Awel y Môr Offshore Wind Farm

Applicant's response to NRW REP1-080-3.1.24 to 3.1.25

Date: 23 November 2022

Document Reference: 3.16

**FIGURE NUMBER:**  
**Figure 2c**

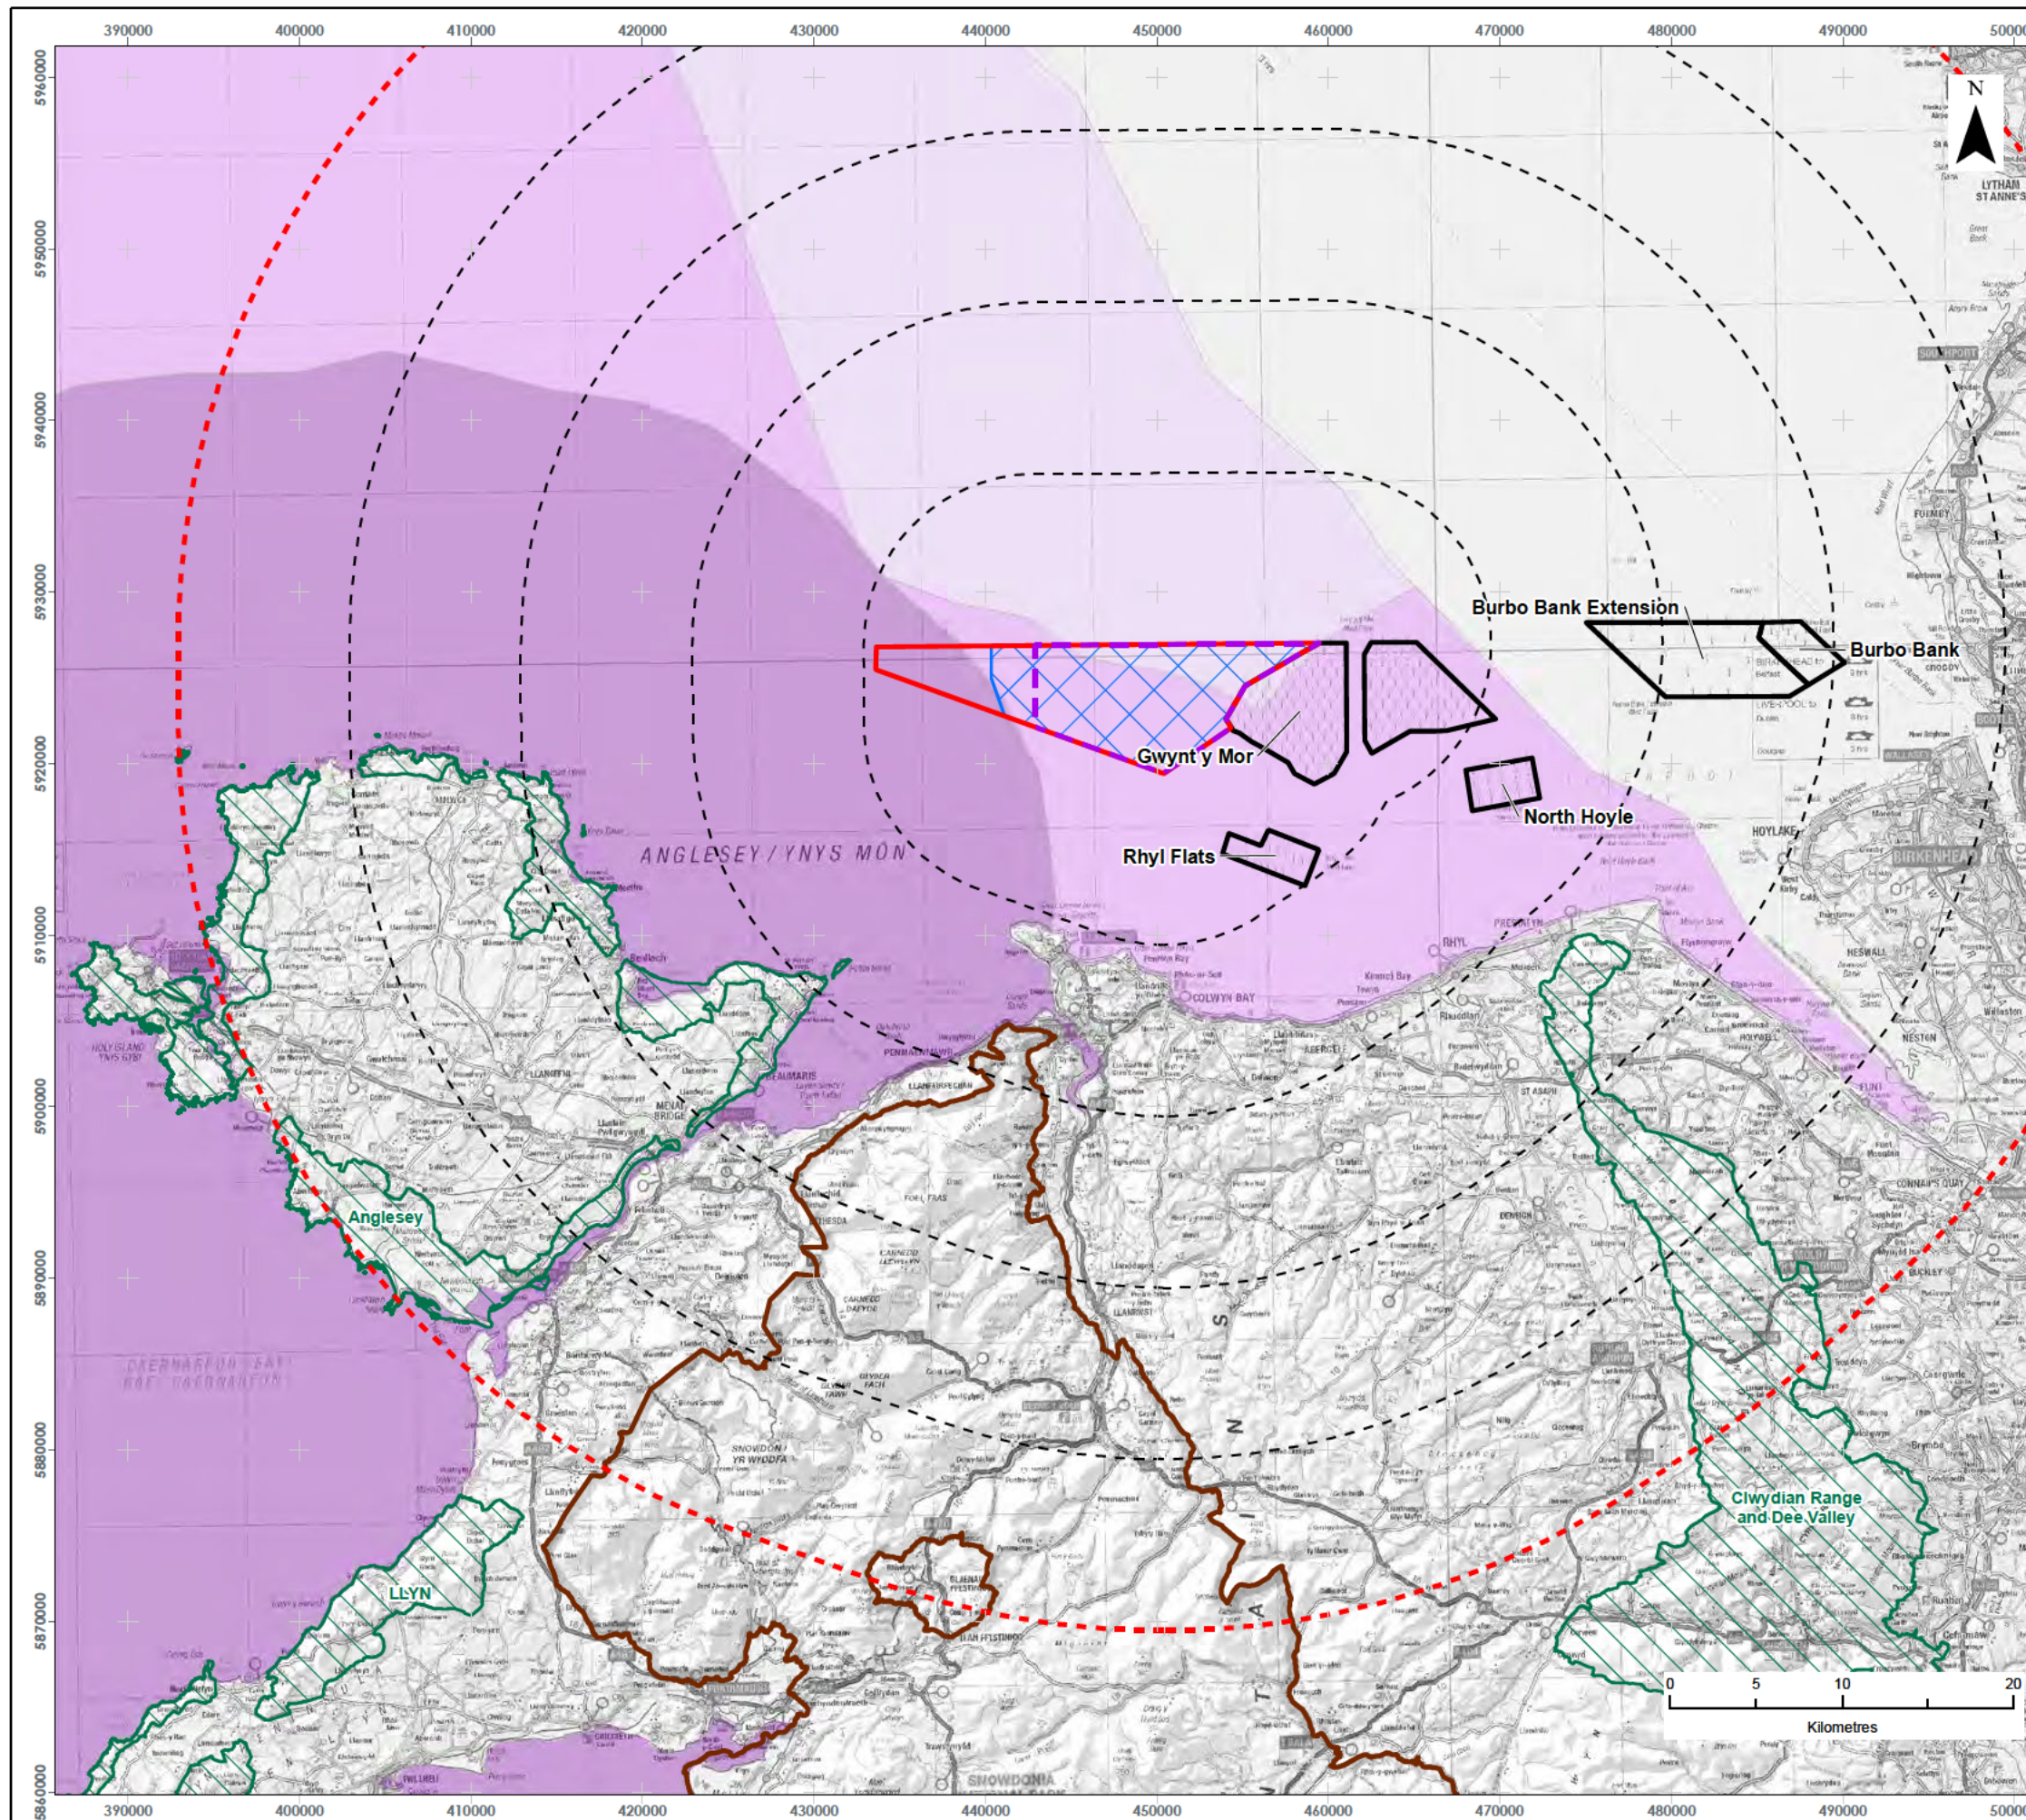
NRW'S SUGGESTED REDUCTION CONSIDERATION	APPLICANT'S RESPONSE
<p>4. If the above is not possible, locate development beyond Stage 1 Report low magnitude buffer distances of the highest potential turbine proposed from National Parks and AONBs (44 km for 301-350m turbines).</p>	<p>The AyM Area for Lease (AfL) was identified through agreement with The Crown Estate in [CHECK date]. Criteria for defining the boundary included that it had to be an extension to the operational Gwynt y Môr Offshore Wind Farm. Other constraints resulted in the boundary being set in its current location. It cannot be moved elsewhere. It is not possible for the AyM array area to be located at distances of 41.6 km or 44 km from the nationally designated landscapes.</p>
<p>6. Locate developments in areas identified as lower sensitivity in the Stage 3 Report.</p>	<p>The Stage 3 report Figure 8 shows the designated landscapes, their seascape settings and their sensitivity to offshore windfarms off North Wales at page 34. The identified sensitivity areas are shown on Figure 2c of the SLVIA Figures (APP-193) along with the boundary of the array area.</p> <p>The AyM array area spans across areas defined as having different levels of sensitivity as follows.</p> <ul style="list-style-type: none"> ▲ Area 1: North East Wales Inshore - Medium Sensitivity ▲ Area 2: North East Wales Offshore - Medium/low Sensitivity

NRW'S SUGGESTED REDUCTION CONSIDERATION	APPLICANT'S RESPONSE
	<p>Notably, Figure 8 on page 11 of the Stage 3 report shows that the majority of the Draft Welsh National Marine Plan area is of High or Medium/High Sensitivity and none of the area within the Draft Welsh National Marine Plan area is categorised as Low so that Medium/Low is the lowest level of sensitivity identified.</p> <p>Embedded mitigation that resulted from the iterative design process between the scoping and application stages removed WTGs from the western part of the AfL, which is identified as being of high sensitivity. The array area is now proposed within areas identified as lower sensitivity, as far as it is possible within the AfL area, as shown on SLVIA Figure 2c (APP-193)</p>
<p>14. Particularly avoid developments within buffer distances of several separate designations.</p>	<p>The Stage 3 report sets out an example of what is meant here. Example 1 shows an OWF site located within a wide bay where there is a National Park or an AONB on the coast indicated on either side of a coastal bay.</p> <p>In this example, not only would both nationally designated landscapes be affected by views of the OWF in their key aspect the views from one nationally designated landscape to</p>
